Scale 1" = 16' 32

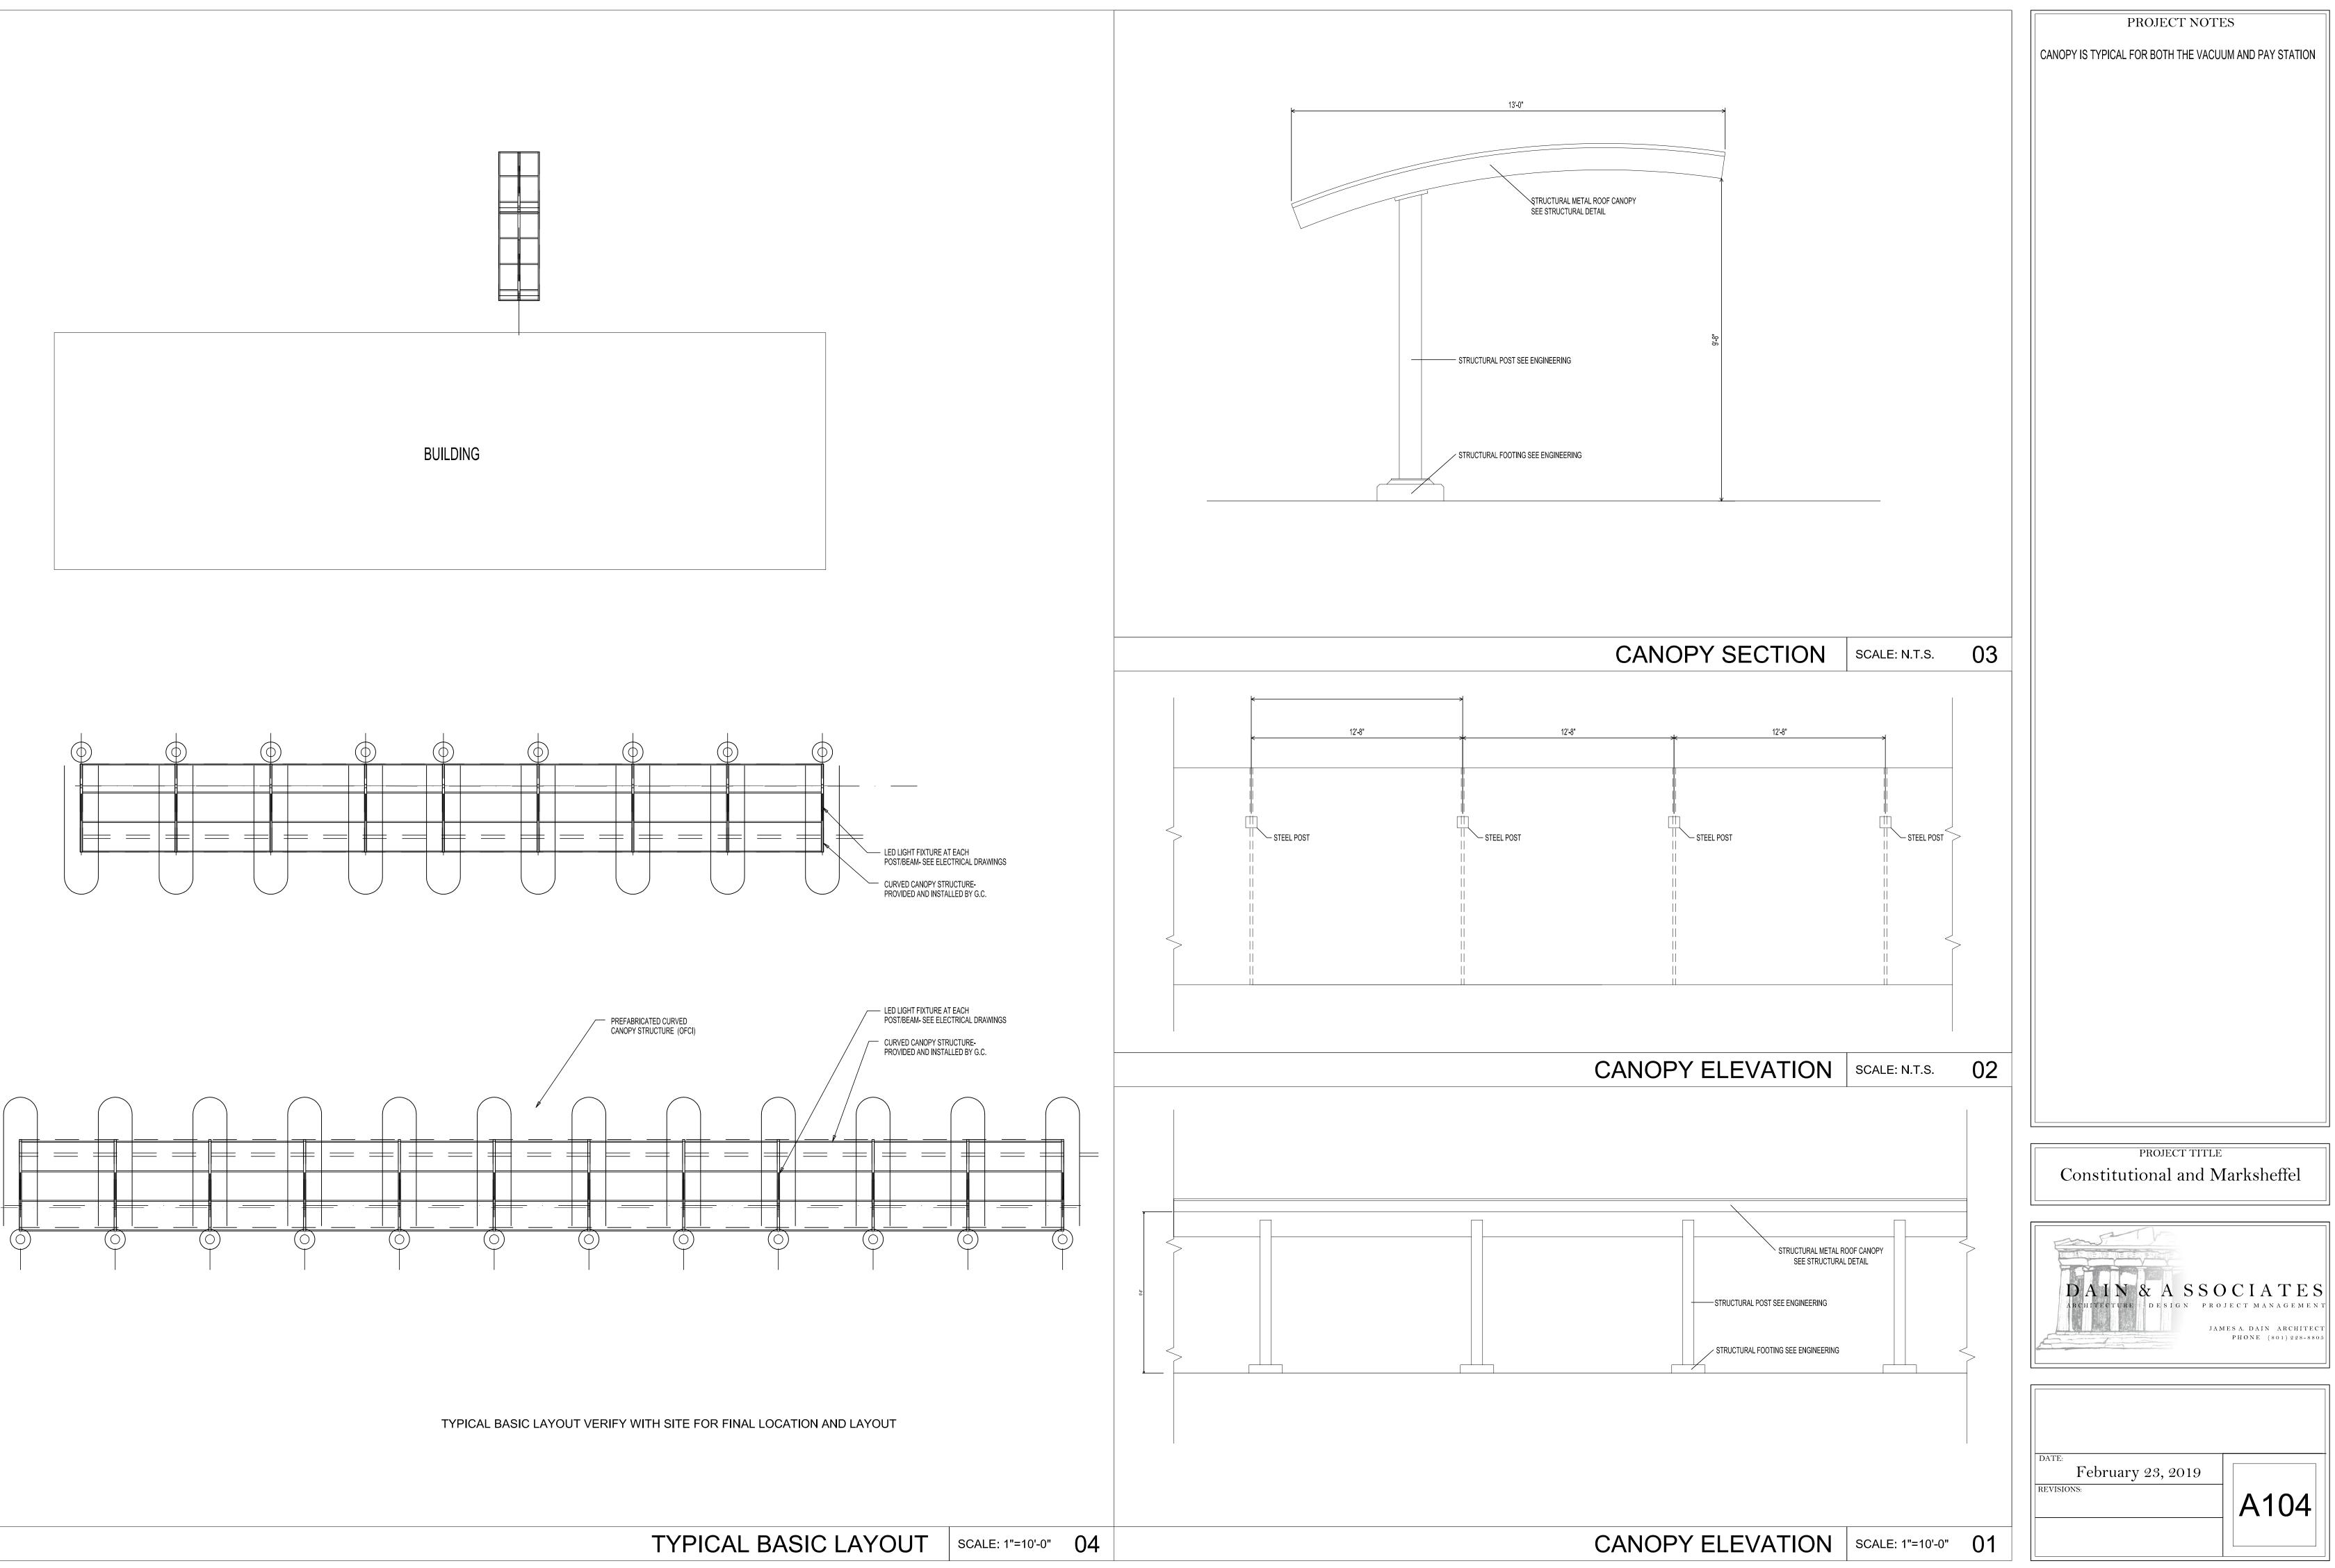
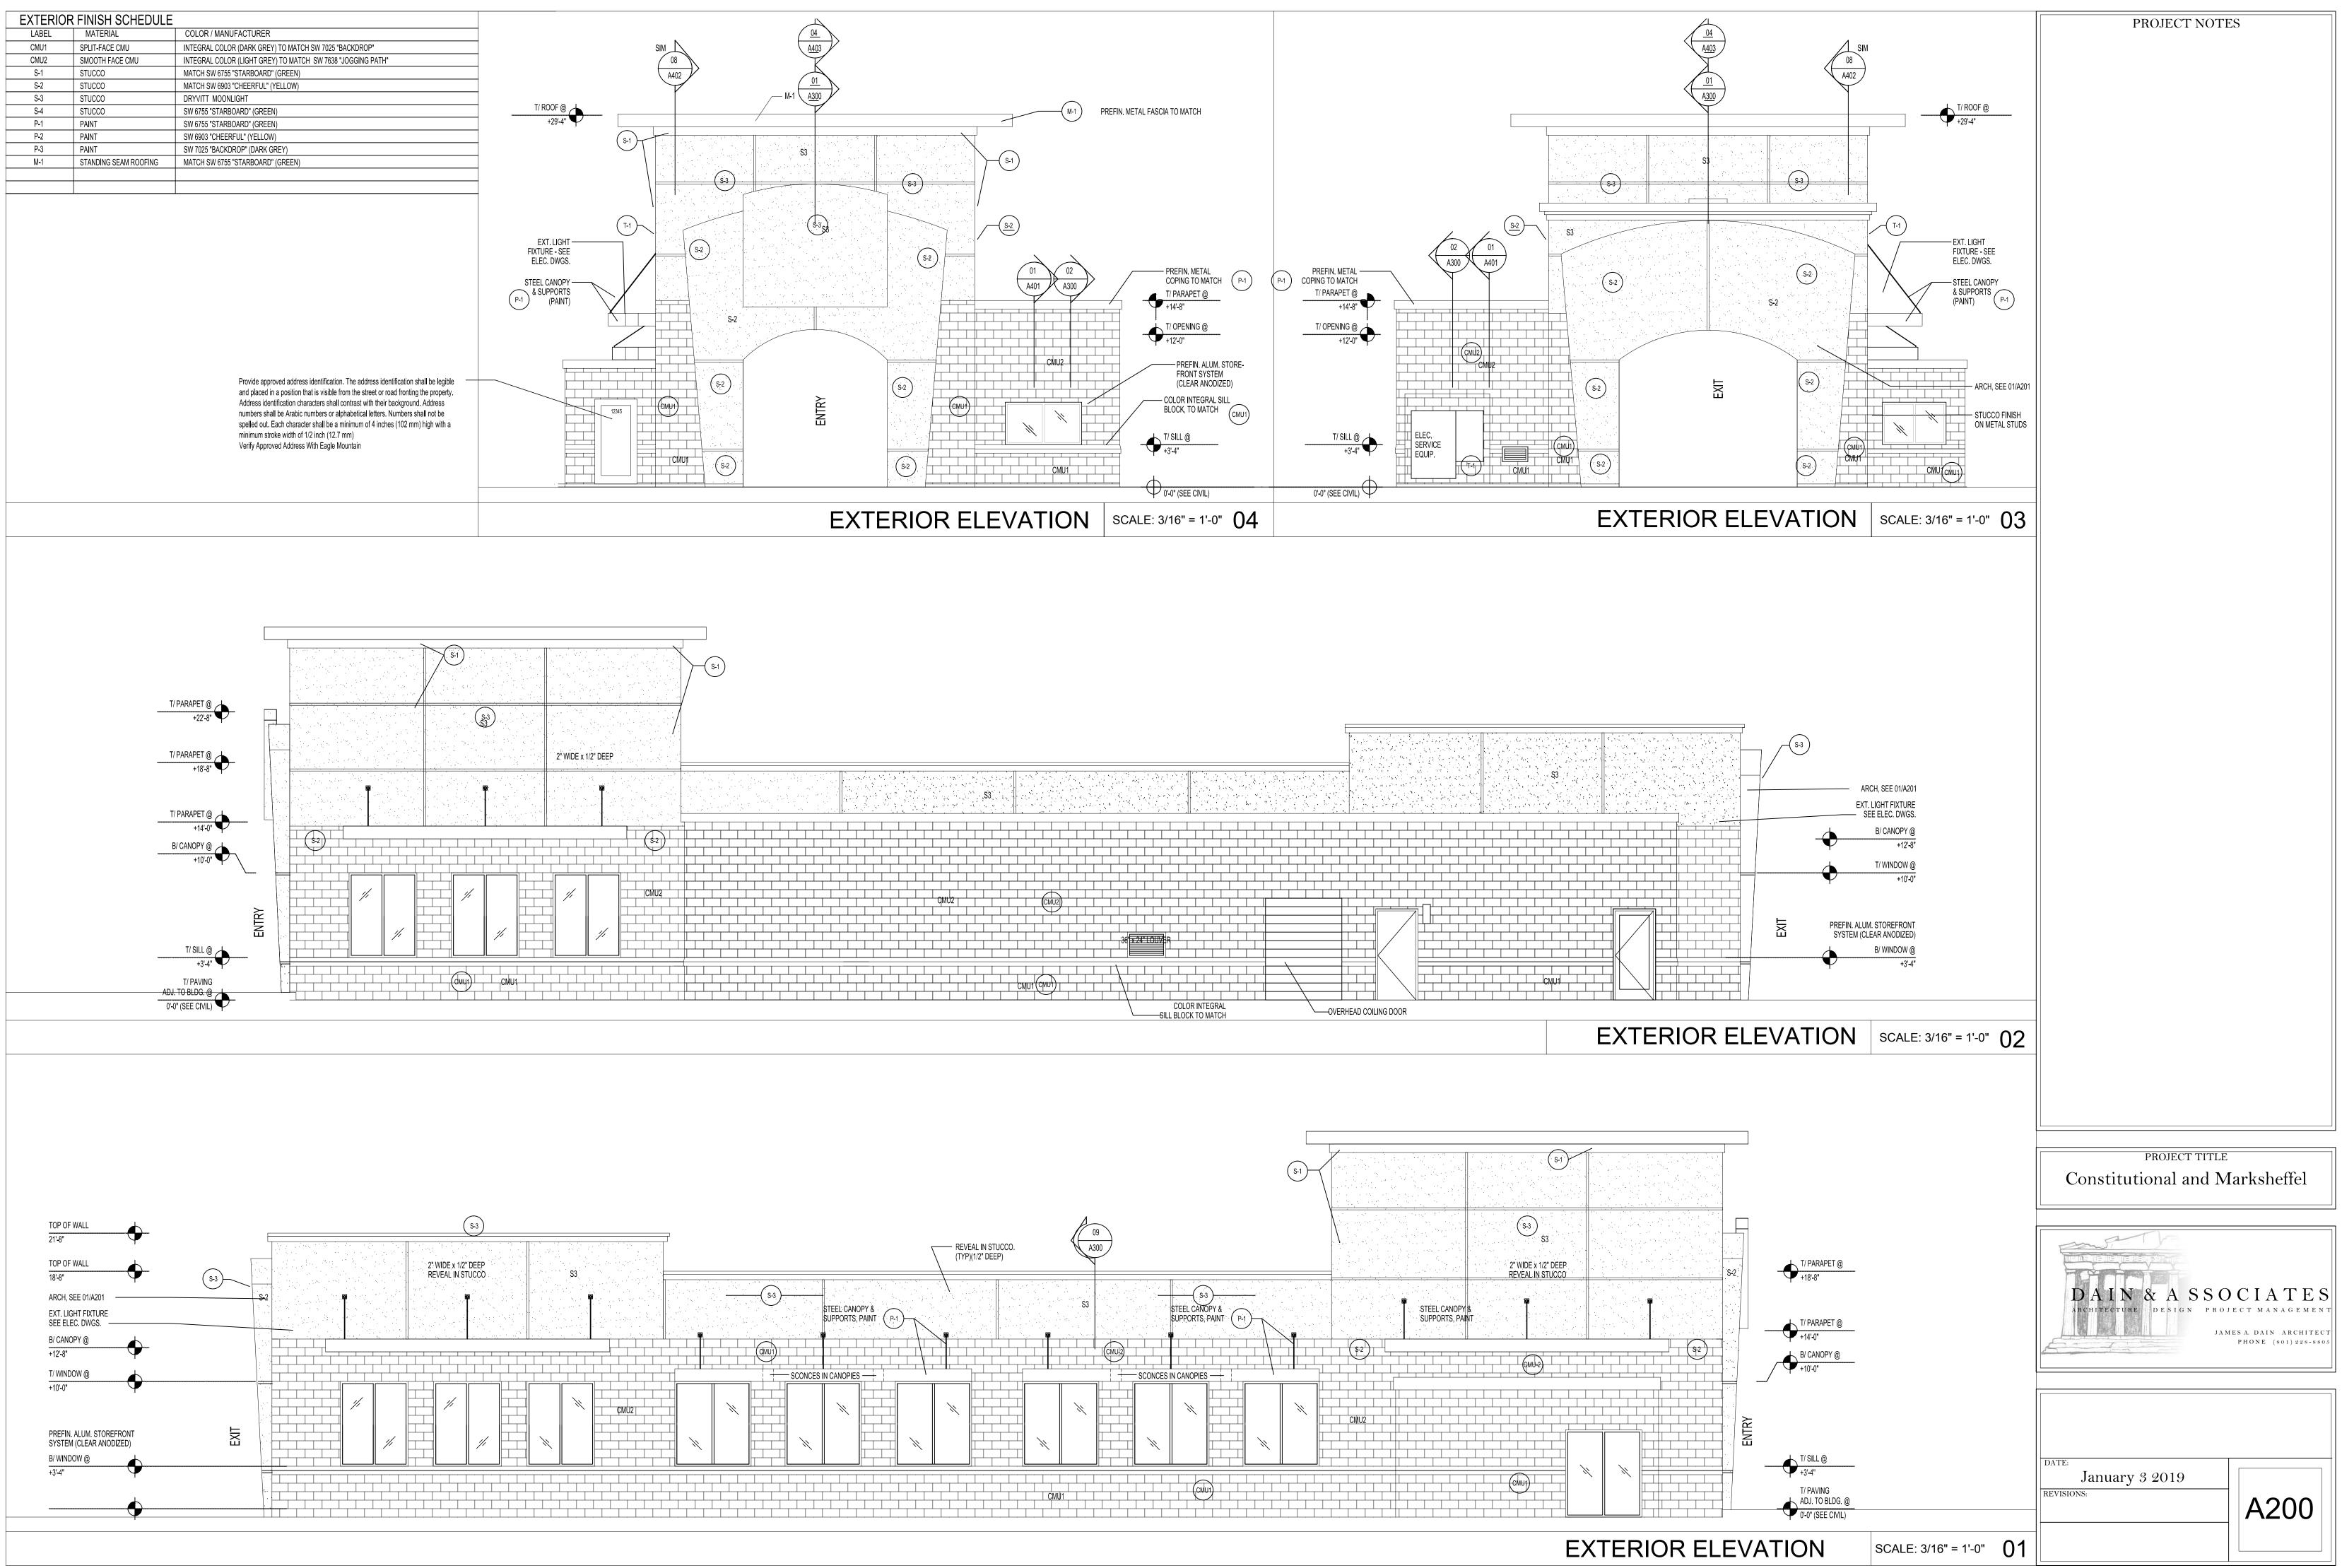
Section 6.2.3(B)(1)(d)
Maximum Levels, on-site lighting shall not exceed 10 footcandles throughout the site.

Layout subject to change based on no vacuum stalls allowed in water easement

1' Shield/Baffle 6" away from the fixture to achieve the spill goal.
